**A303 Amesbury to Berwick Down
(Stonehenge) Wiltshire
TR010025**

**Wiltshire Council (A303-AFP022)
Response to Proposed Changes
Consultation Report (Non-Statutory)
[REP8-015]**

Application Document Number	Rev
TR010025 - 2.12	P03

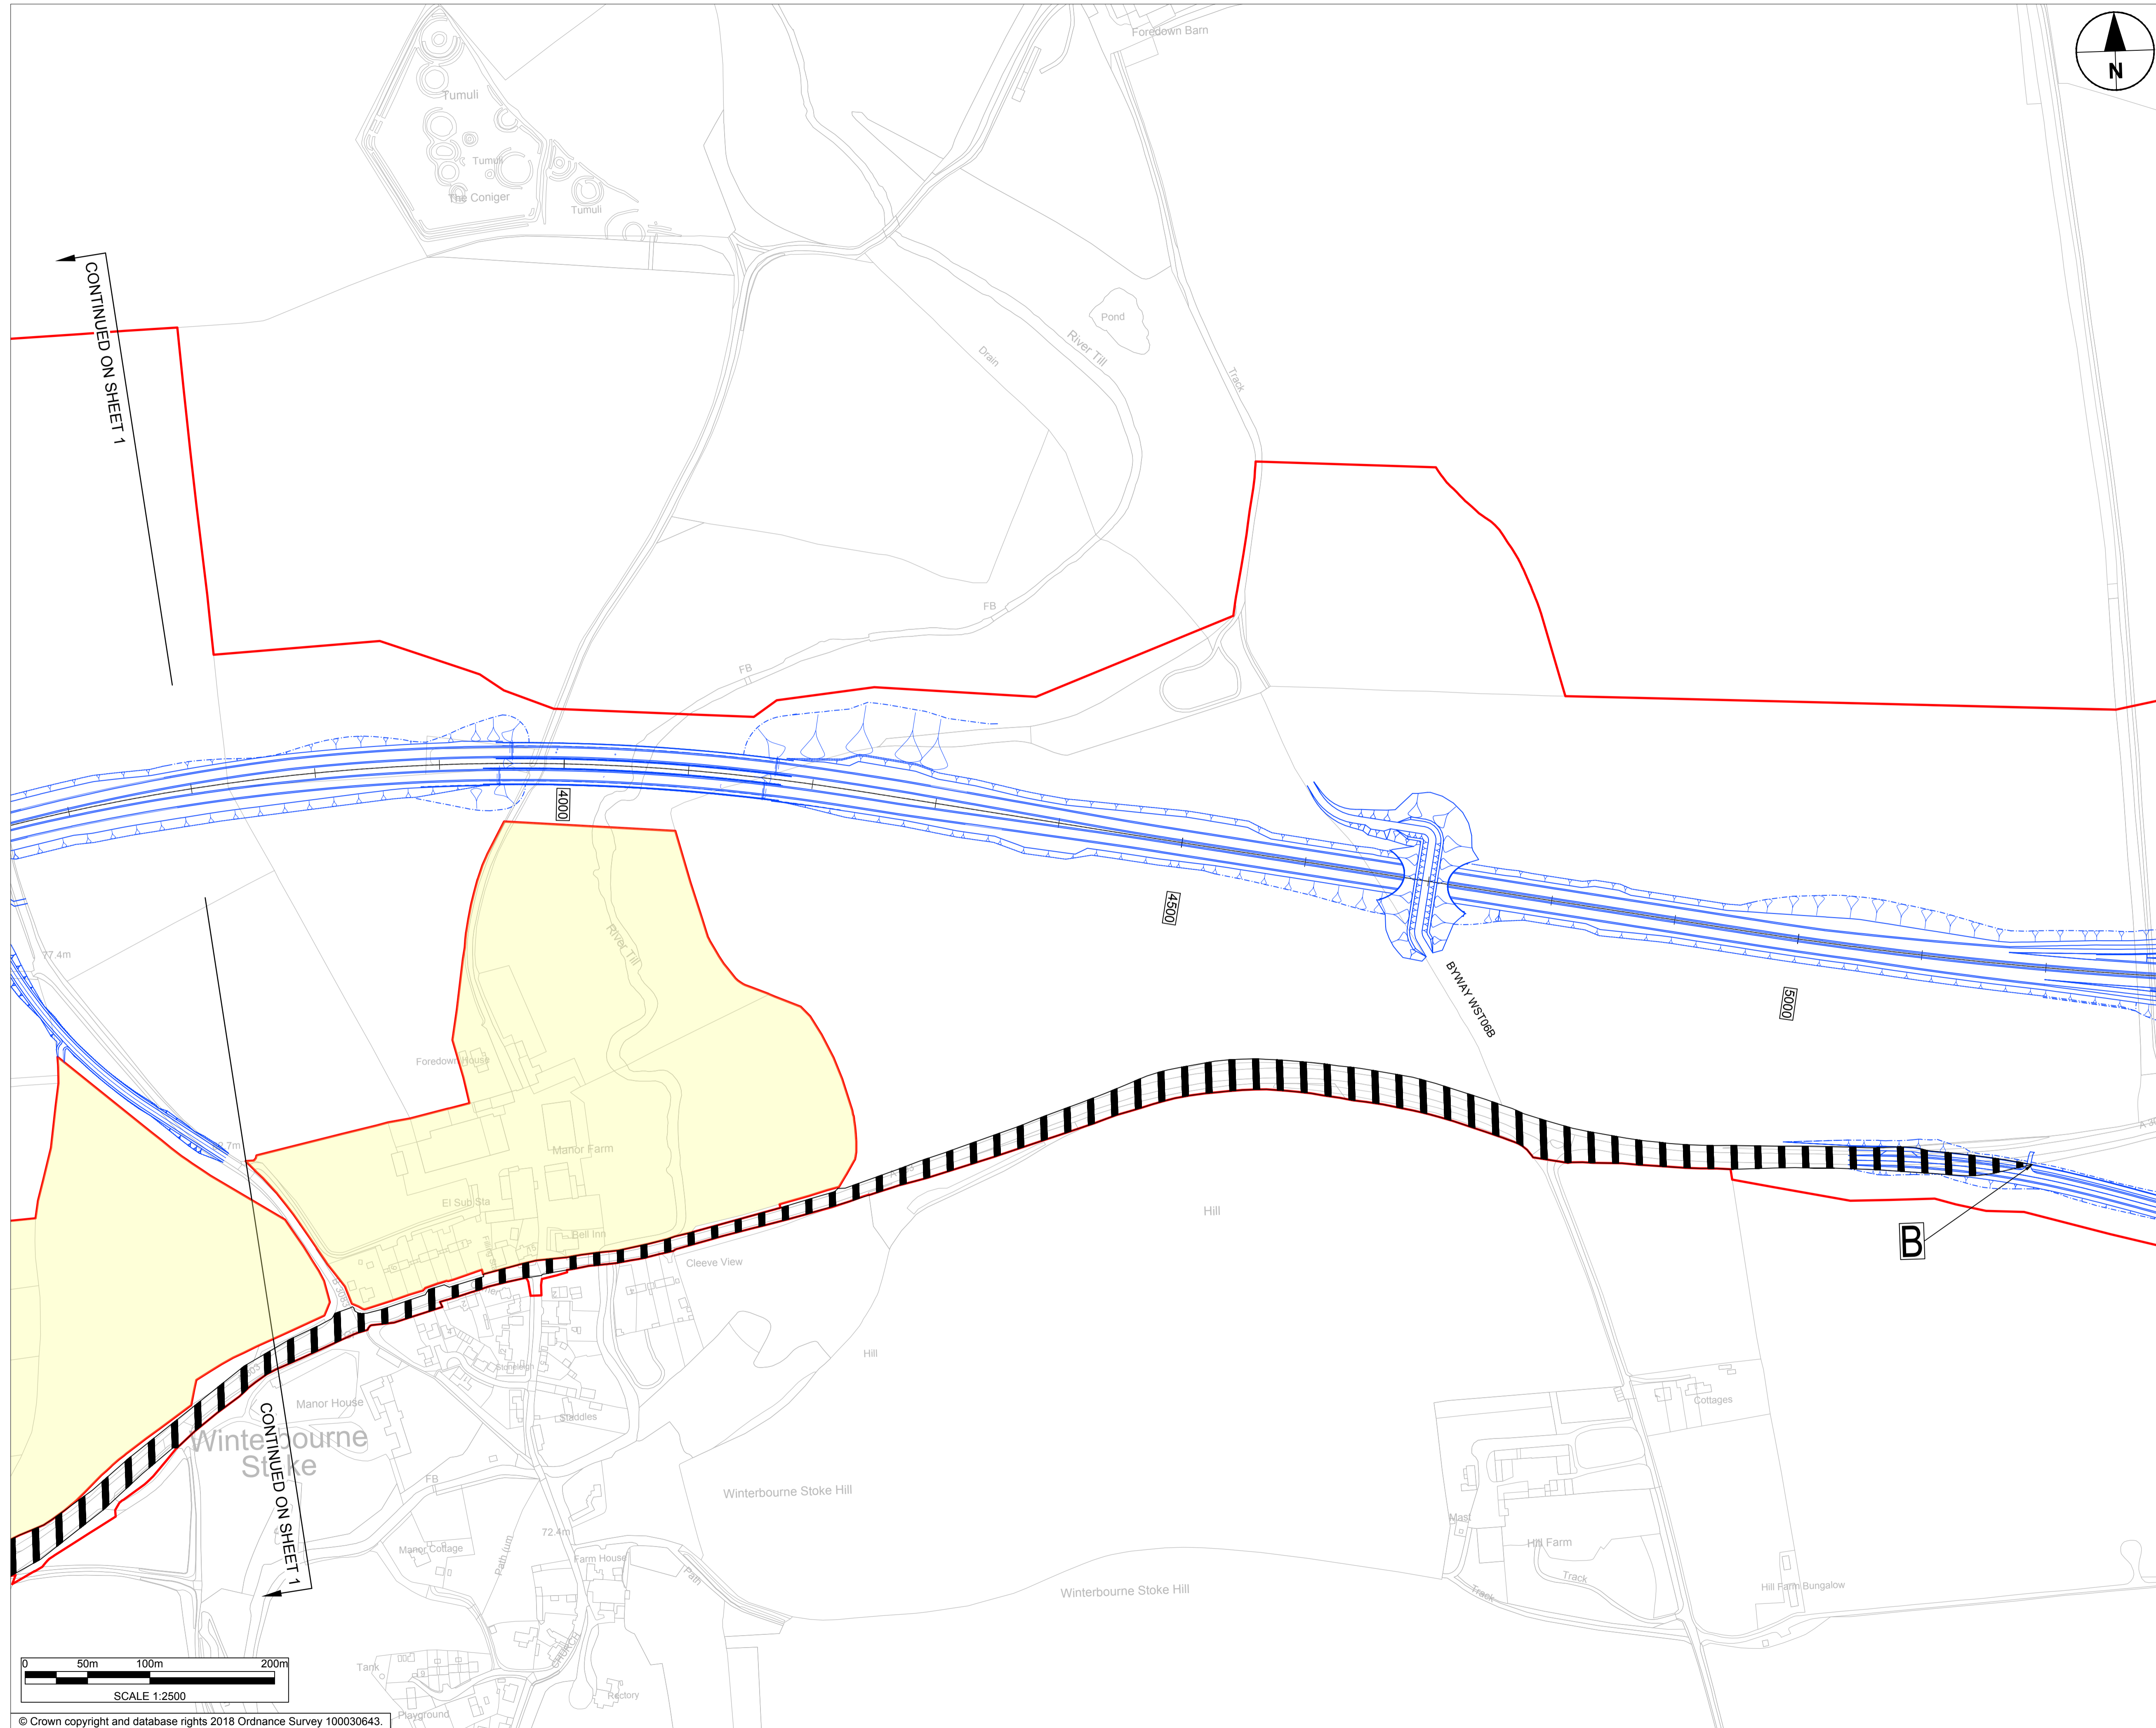
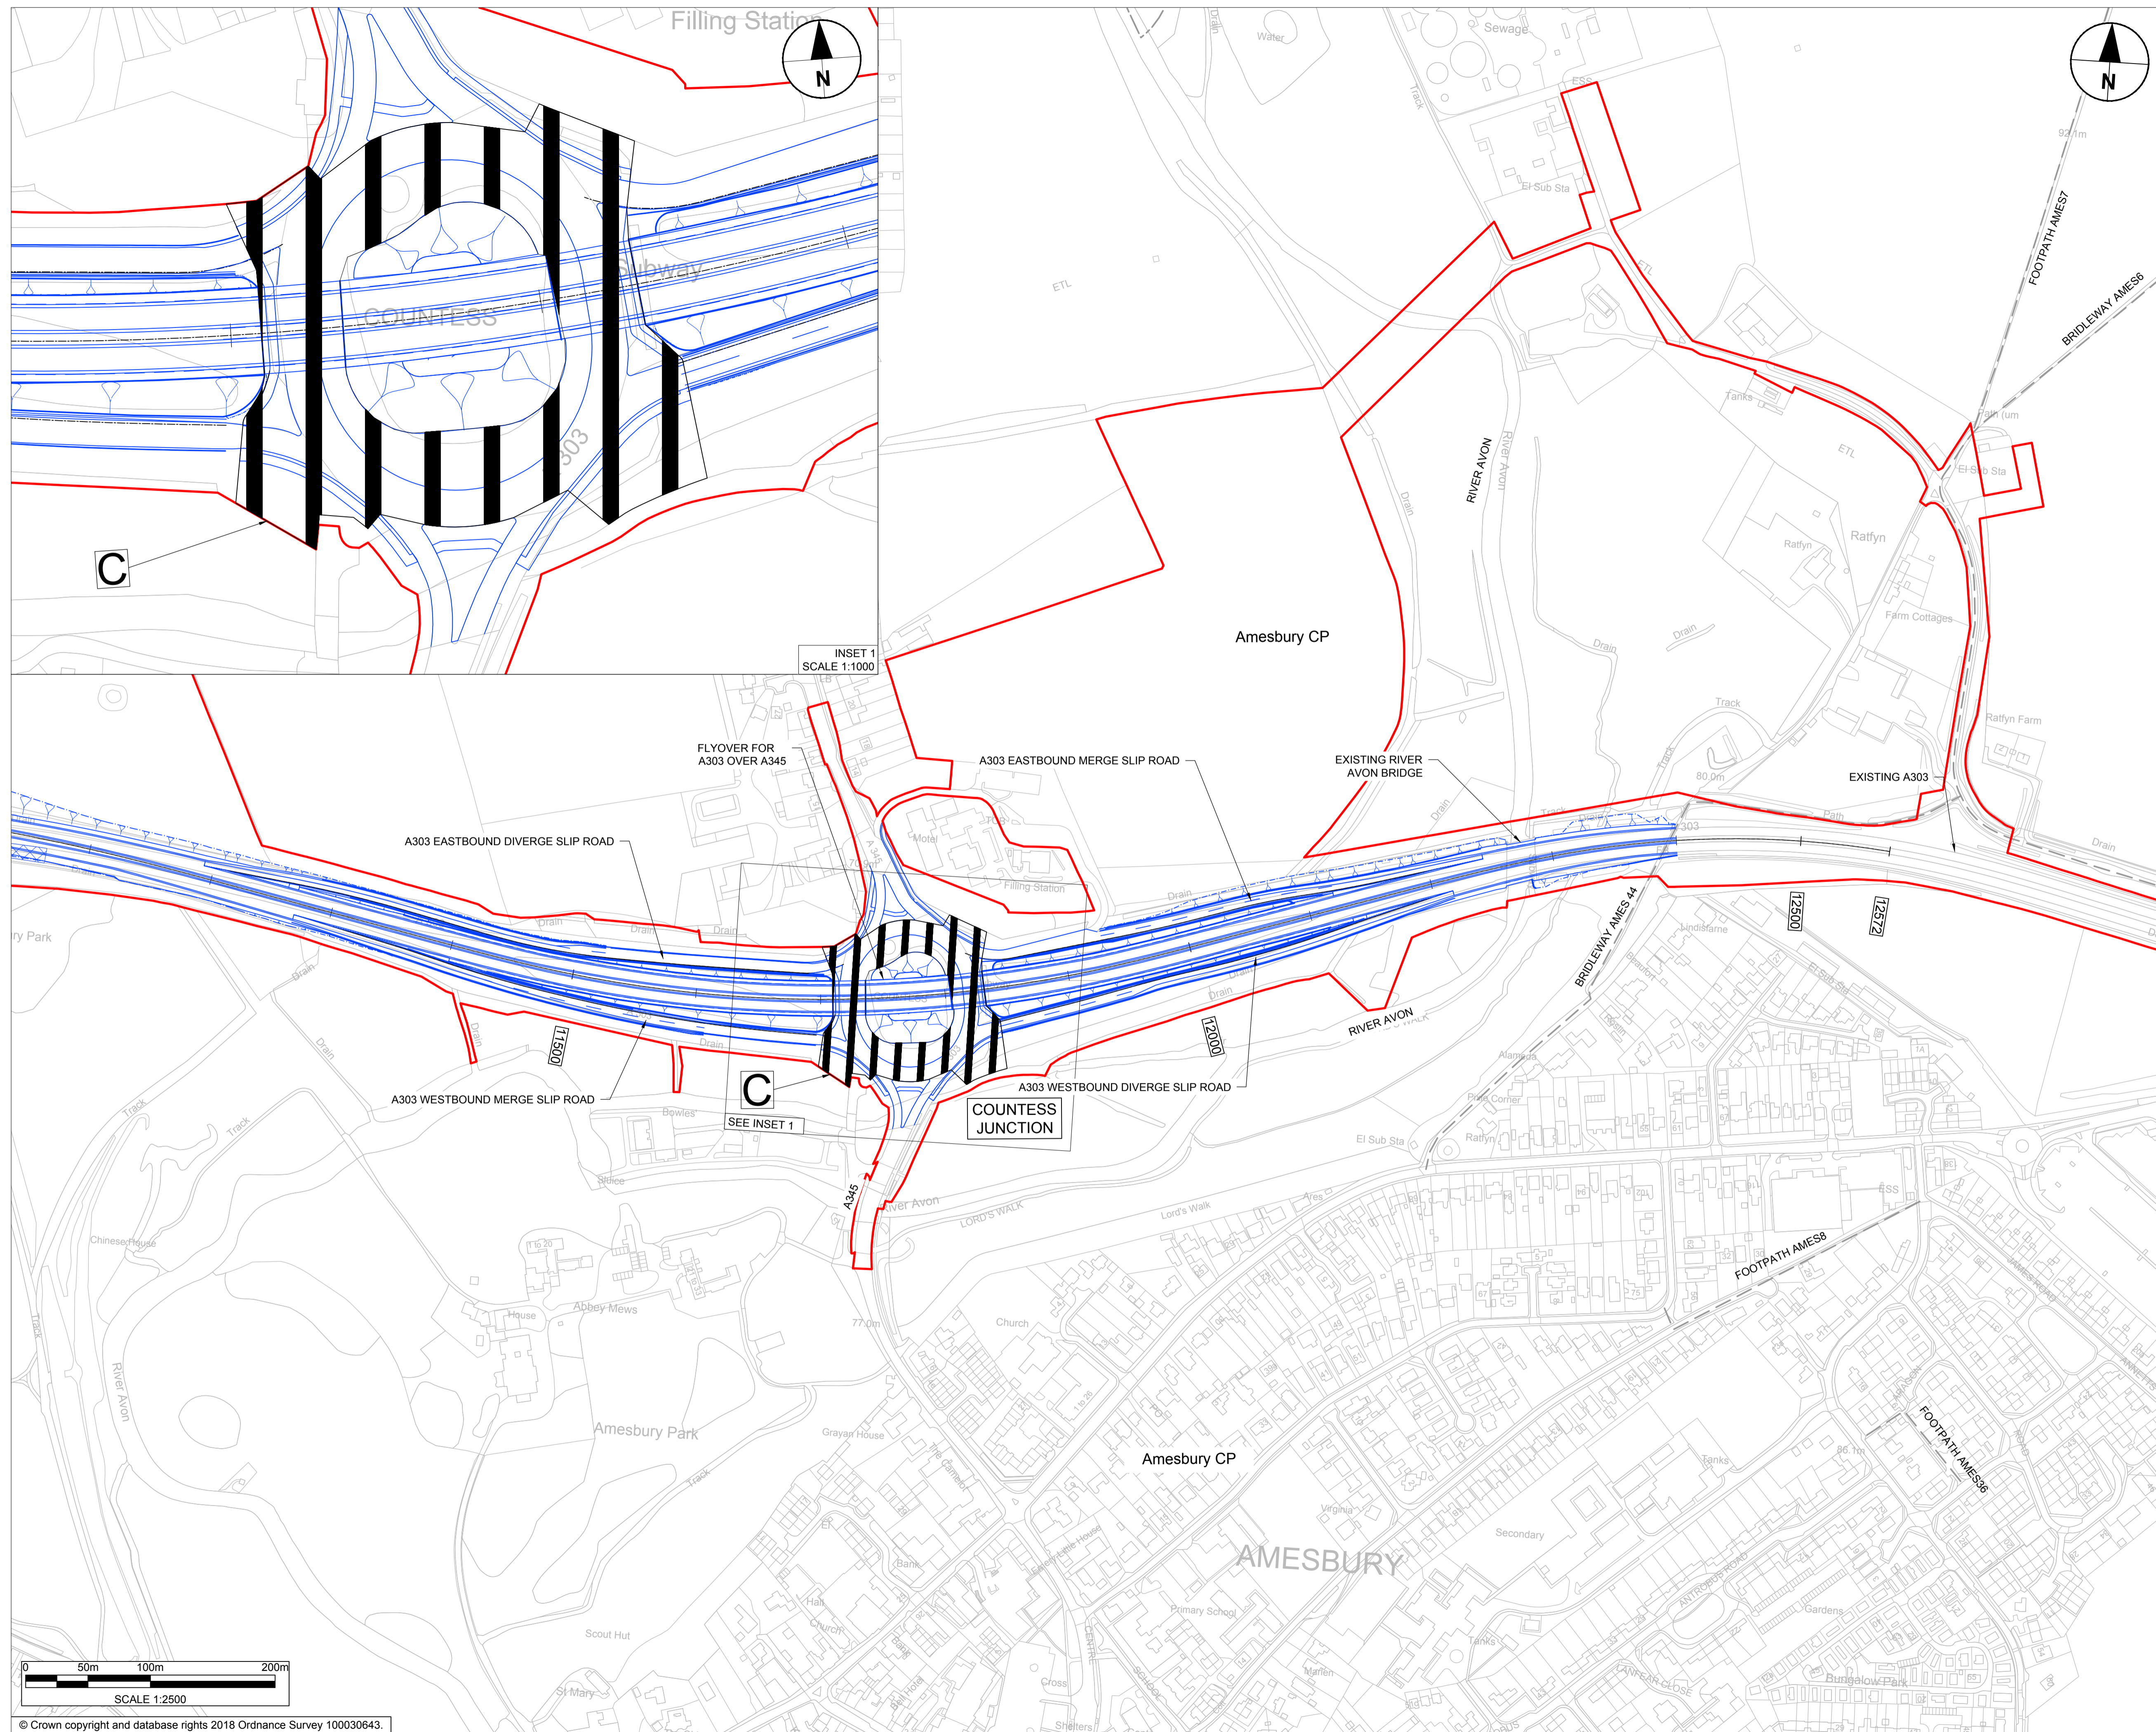
- 2.1 The Council, at the Traffic and Transportation Issue Specific Hearing on 22nd August, raised concerns in response to the detail of the proposals for the de-trunking of the existing trunk road at Countess Junction. Subsequently, the Council has liaised with HE with a view to establishing a drawing which, in the parties' views, shows an area for de-trunking which provides for the north-south footways on both east and west sides of the junction to be included within highways which will be vested in the Council; the de-trunking will follow a process in accordance with the provisions of the Side Agreement currently in draft. The extent of the de-trunking has been subject to the two authorities agreeing on the current boundary between Wiltshire Council and HE on both the south and north sides of the junction, this is in the absence of any known definitive records held by either party.

- 2.2 The Council is now satisfied that the extent of the de-trunking proposals, as shown in Figure 5.1 of the Proposed Changes Consultation Report (Non-Statutory) submitted by HE, is acceptable in all regards.
